CITY OF ALBUQUERQUE

Re: Whole Foods
2100 Carlisle Blvd NE, Suite A
Request for Certificate of Occupancy- 30 Day Temp
Transportation Development Final Inspection
Plan Date: Stamp 6-29-21, AA 12-4-23 (H17D097B)
Certification dated 1-28-24

Based upon the information provided in your submittal received 2-1-24, Transportation Development has no objection to a 30-Day Temporary Certificate of Occupancy. This letter serves as a "green tag" from Transportation Development for a 30-Day Temporary Certificate of Occupancy to be issued by the Building and Safety Division.

**SITE PLAN FOR BUILDING PERMIT**

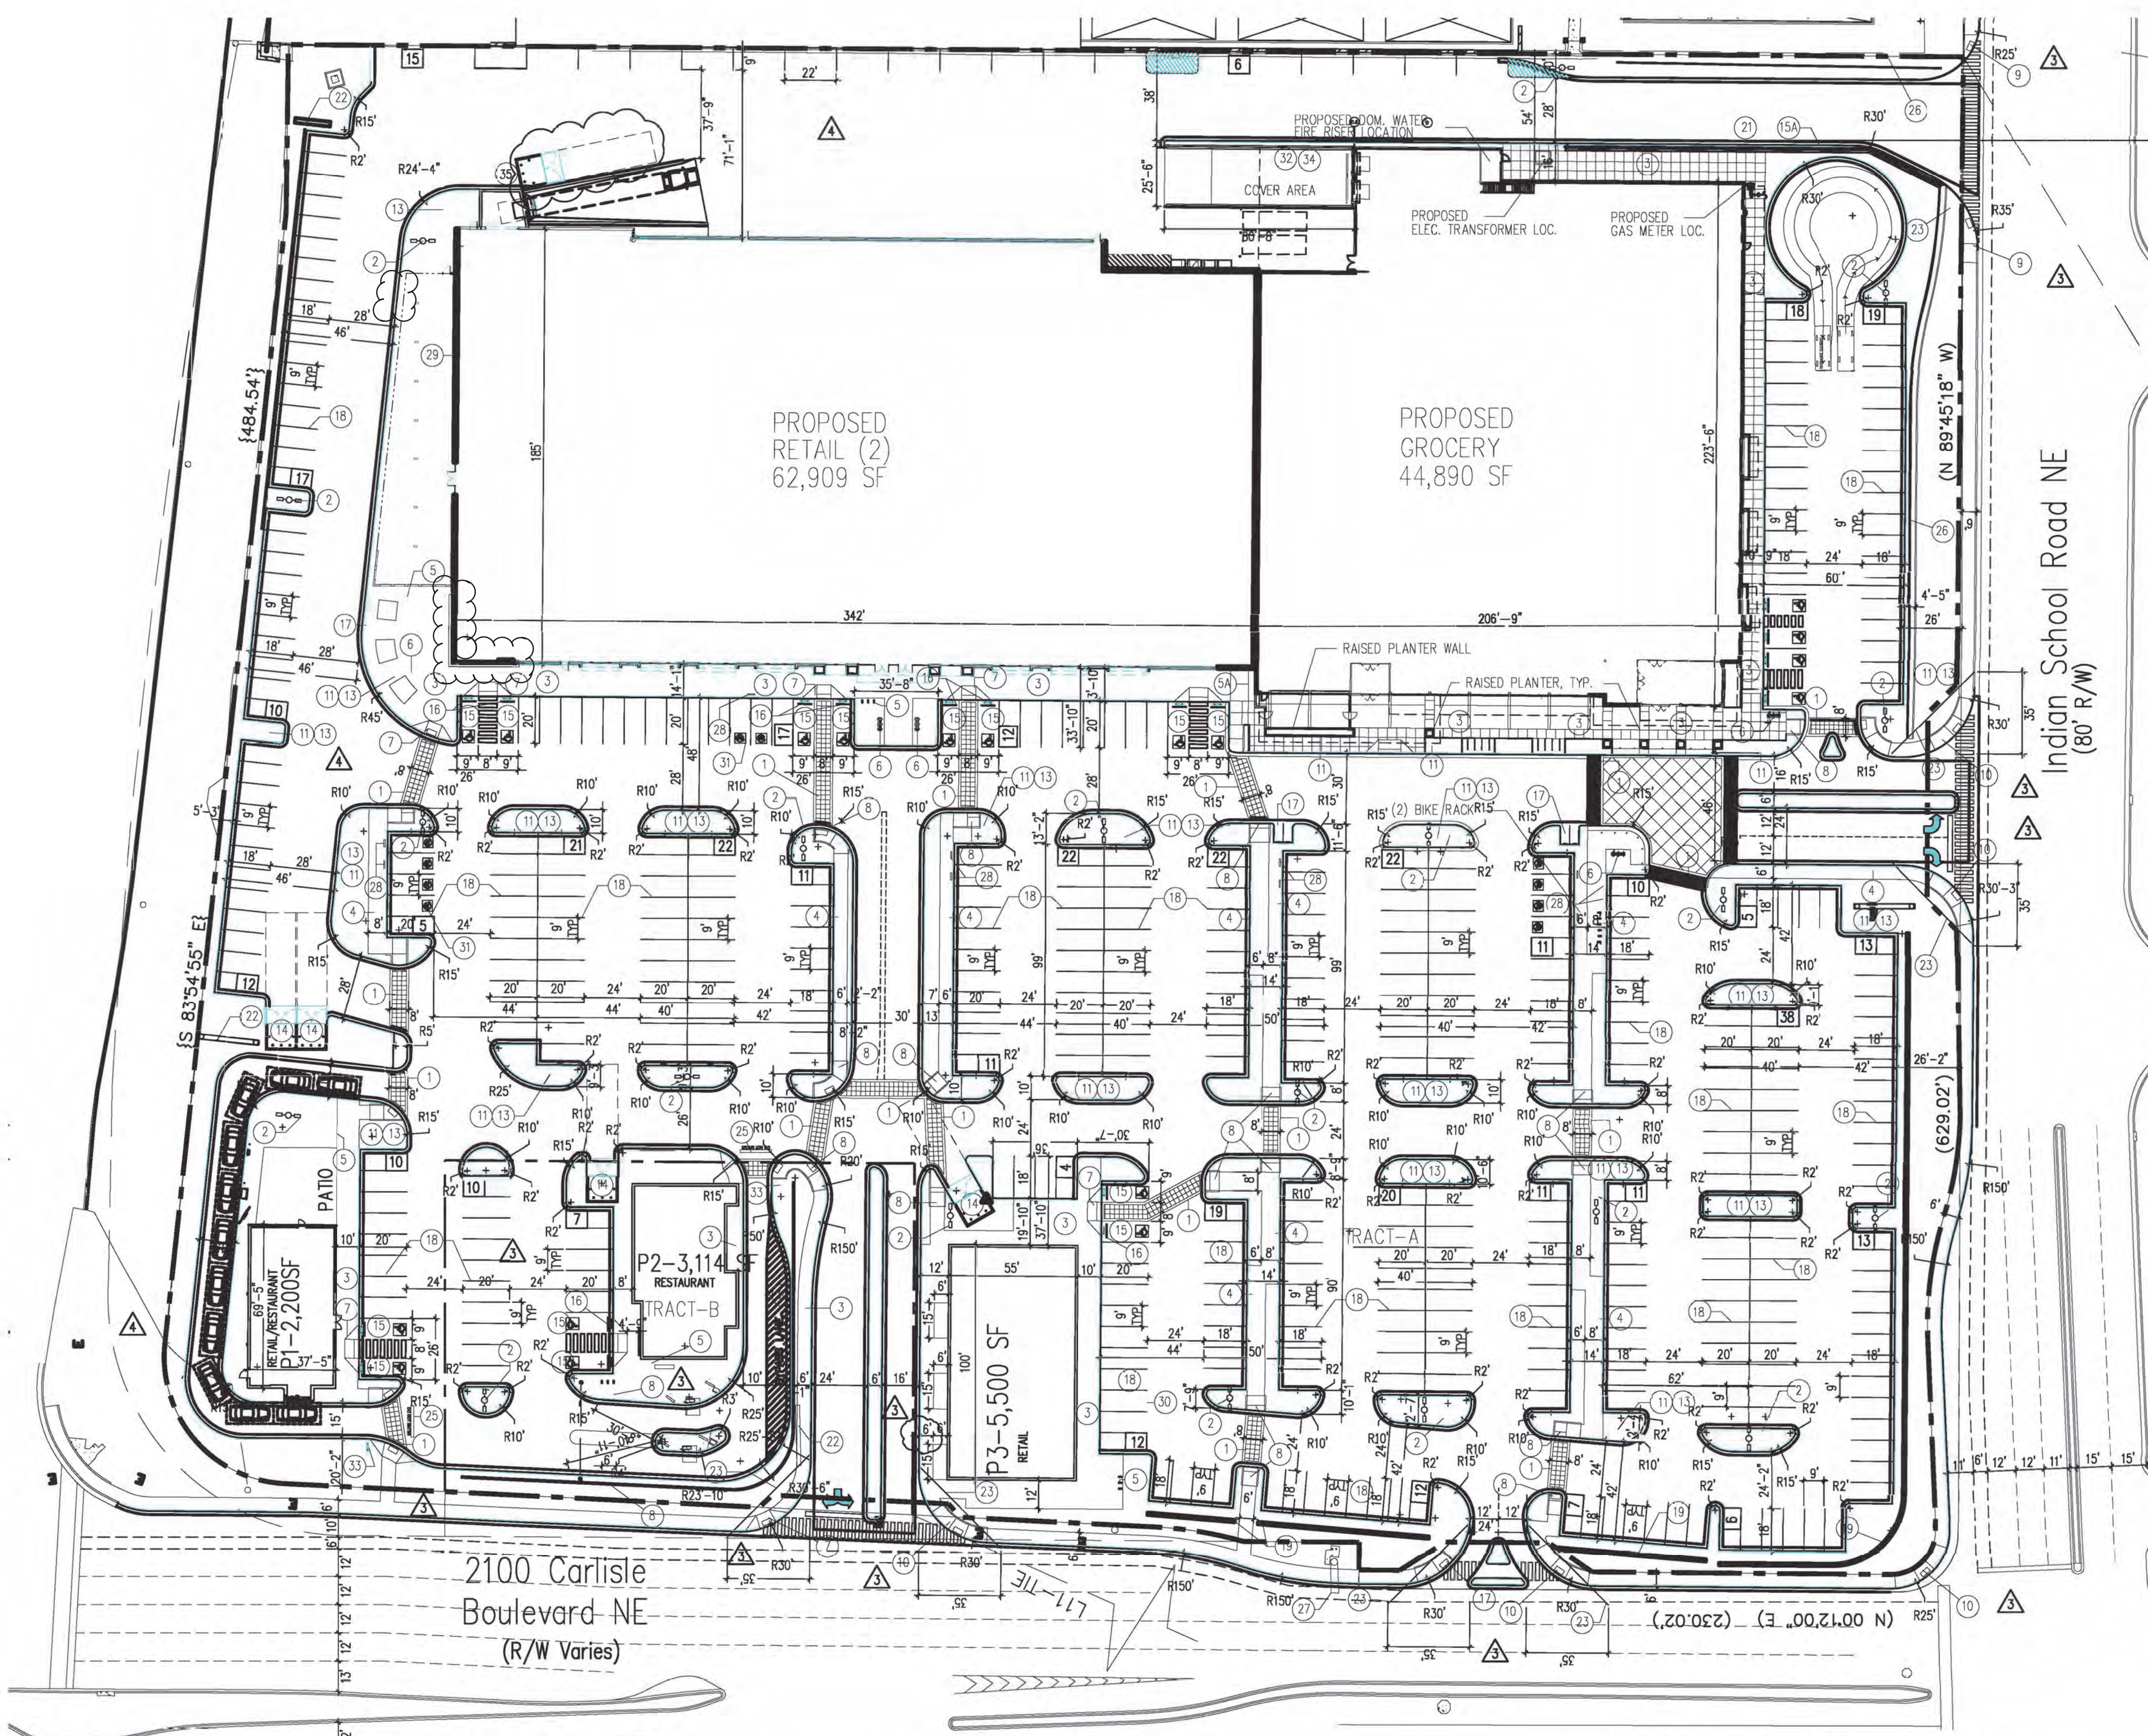
1. The Conex box is to be removed from the parking lot.
2. Add truncated domes to the ramps for the pedestrian pathway from Indian School Rd.
